American Dog Pros Site Plan

PCD# PPR2220

Landscape Plan Drawings_V2.pdf Markup Summary

Footprint of all existing and proposed buildings and the setback distances from each existing and proposed structure to the property lines. No sidewalks.

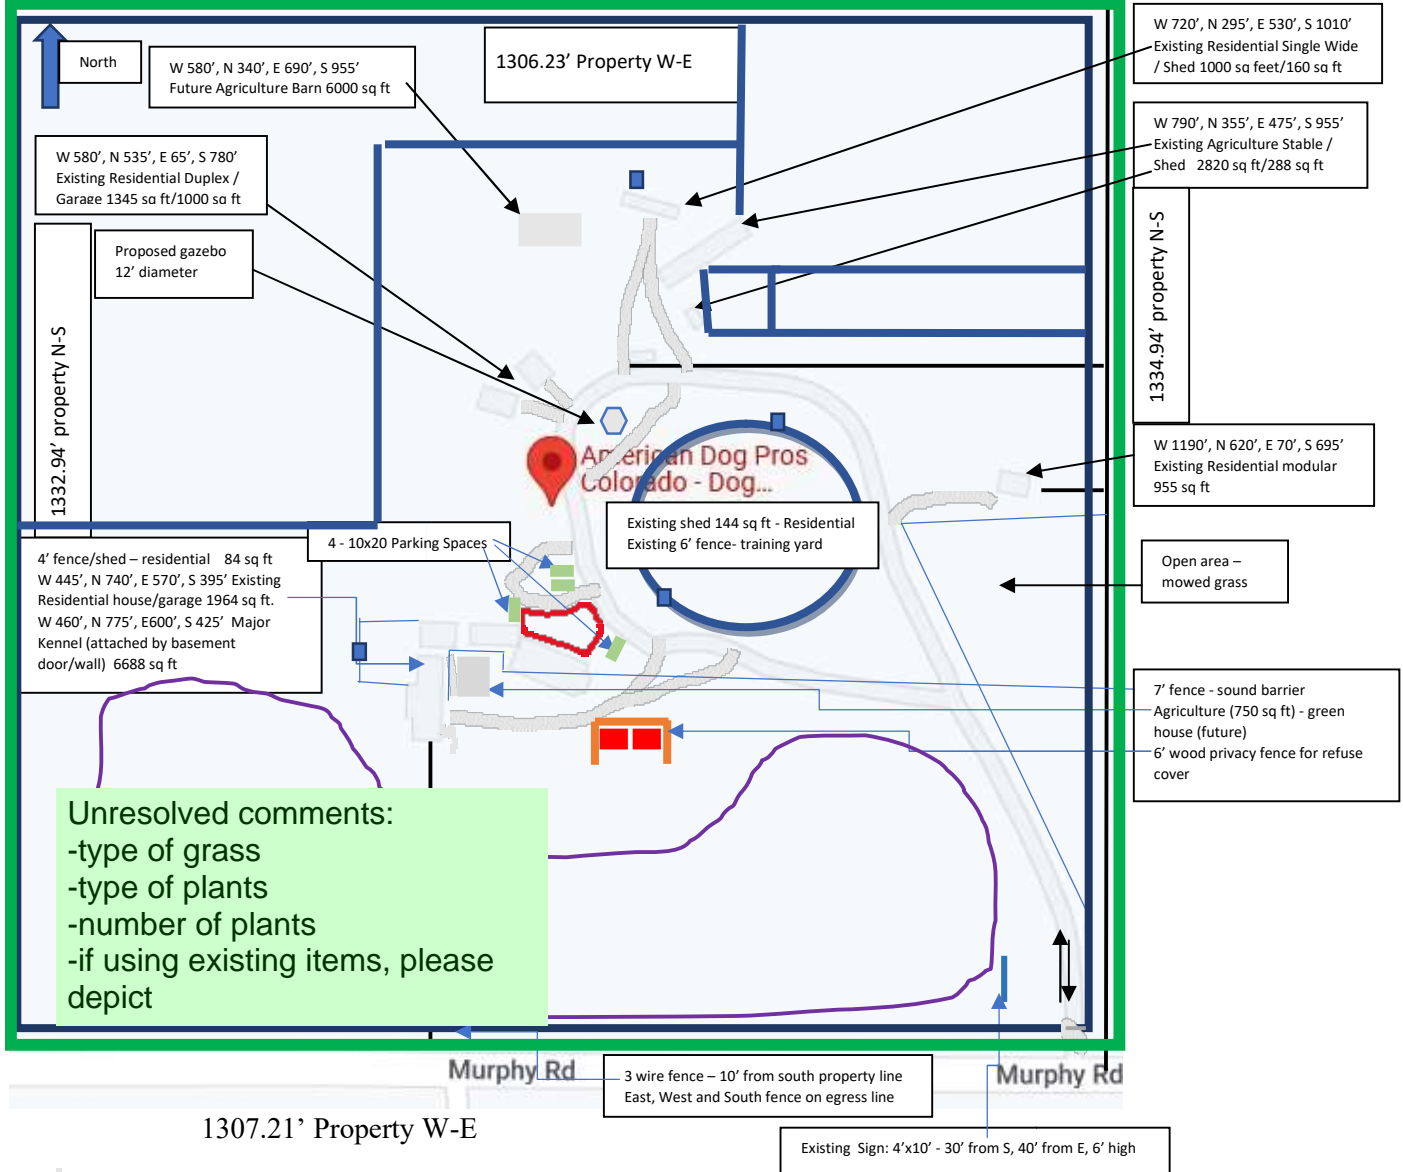
Please review the landscape plan checklist and comments from the site plan. A lot of the same items are missing. Some items from this plan also conflicts with the other plan. Please use one plan to show all applicable checklist items on the plan to use as the main site development plan. The landscape plan shall also mention the landscape deviation request.

Please review the landscape plan checklist and comments from the site plan. A lot of the same items are missing. Some items from this plan also conflicts with the other plan. Please use one plan to show all applicable checklist items on the plan to use as the main site development plan. The landscape plan shall also mention the landscape deviation request.
